# City of Albuquerque Stormwater Construction Site Inspection Report

Project Name:	Storm Cloud Unit 5				
Location:	Tierra Pintada & DownBurst				
Site Contact Name & Agency	Kevin Griffin	ESC File No.	H09E022B		
	D.R. Horton	NPDES Id. No.	NMR10012Y		
Inspection Date:	04/04/19	Start/End Time:	1330/1430hrs		
CoA Stormwater Inspector:	Timothy Sims, Stormwater Inspector				
Present Phase of Construction:	Home Construction				
Type of Inspection:	<input checked="" type="checkbox"/> Regular	<input type="checkbox"/> Storm Event	<input type="checkbox"/> Post Storm Event >0.25"	<input type="checkbox"/> 311/Complaint	<input type="checkbox"/> Follow Up

**Erosion Sediment Control Plan**

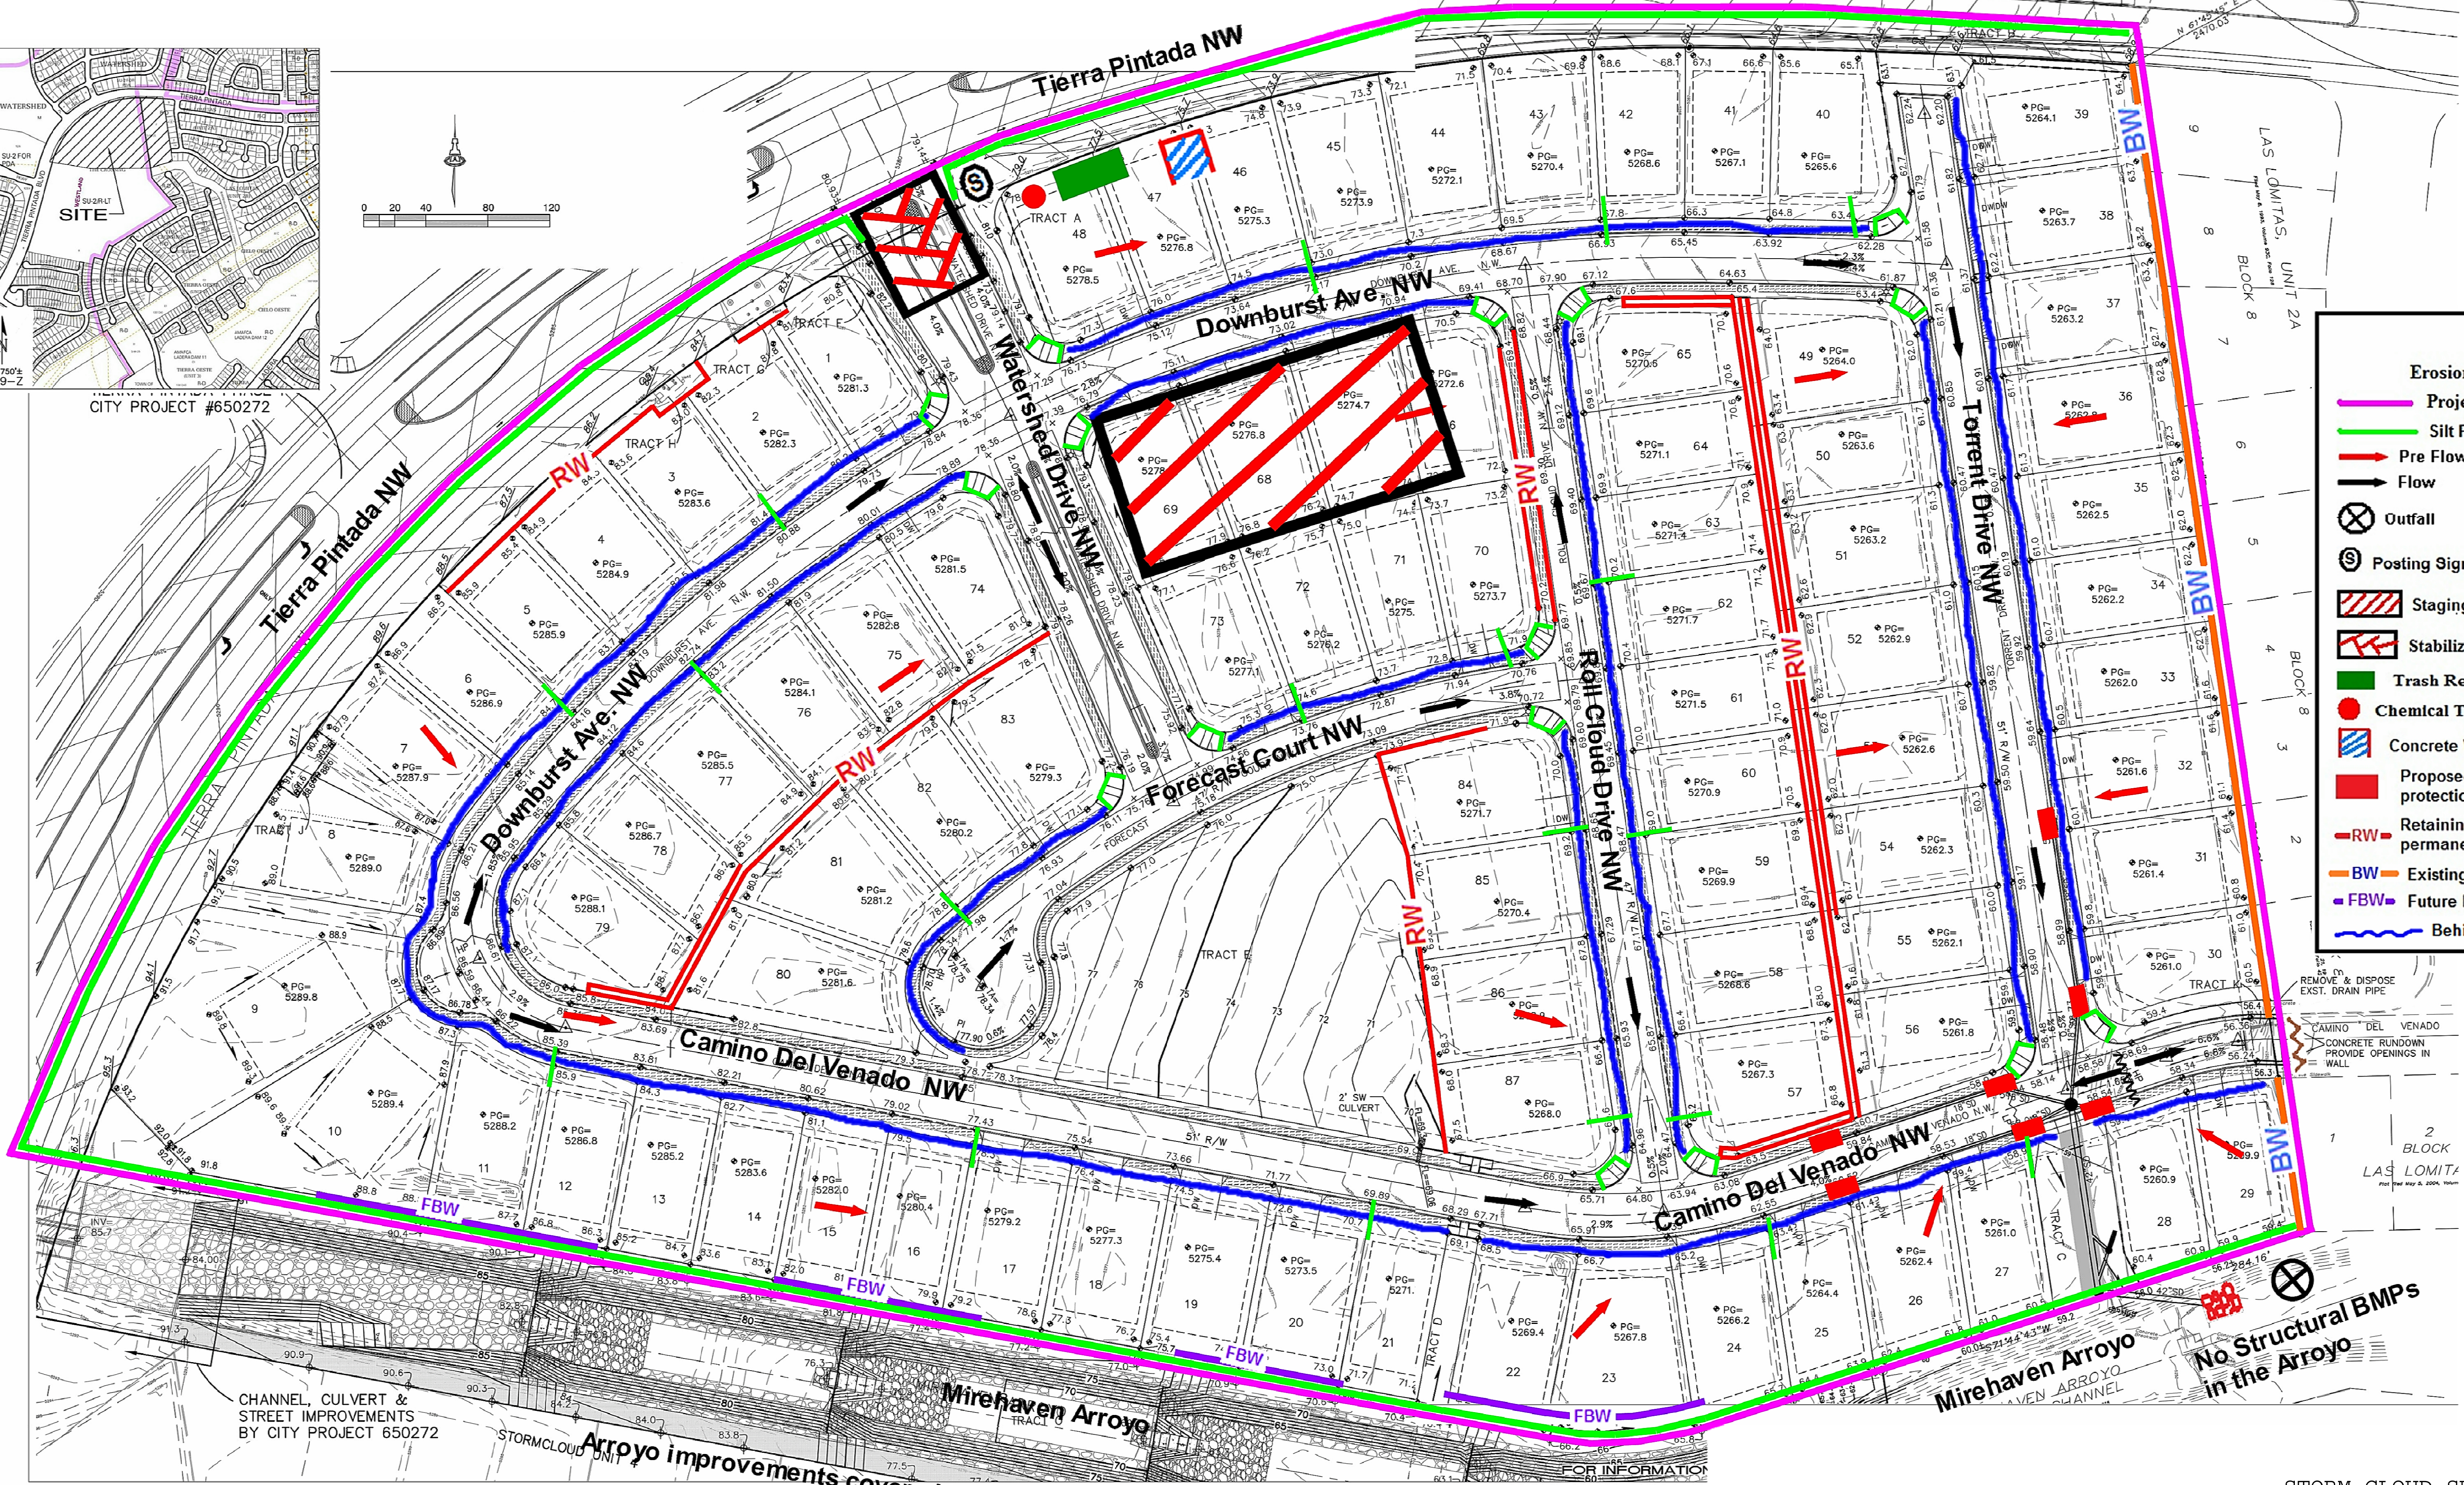
2.2.3	Sediment control along any perimeter	X	Torrent Dr requires sediment BMP's (2109-2119)at curb/sidewalk
2.2.3	Sediment control along any perimeter	X	8709 Forecast Ct sediment BMP at curb/sidewalk

2.2.5	Manage stock piles	x	stock piles in front yard require sediment BMP's
2.2.5	Manage stock piles		on Torrent-2109,2113,2115,2119
2.2.5	Manage stock piles		on 8709 Forecast

2.3.2	Equipment and vehicle washing		
2.3.3	Building material storage		
2.3.3	Fuel, oil, hydraulic fluid, petroleum products and chemical storage		
2.3.3	Construction and domestic wastes	x	8604 construction debris in front - clean

2.3.3	Construction and domestic wastes		
2.3.4	Washing applicators used for paint, stucco, concrete, etc.	x	2109, 2113, 2115,2119 Torrent clean up washout/ utilize outpak or equal

2.3.4	Washing applicators used for paint, stucco, concrete, etc.	x	2100 Roll Cloud mitigate washout
2.3.4	Washing applicators used for paint, stucco, concrete, etc.	x	8709 Forecast Ct mitigate washout see photo

2.3.4	Washing applicators used for paint, stucco, concrete, etc.	x	8604 Down Burst mitigate washout
2.1	Discharge off site? (Y/N)	No	
4	Self Inspection Reports	requested	Latest report Date:

Maintenance or corrective actions are to be completed within seven (7) days.
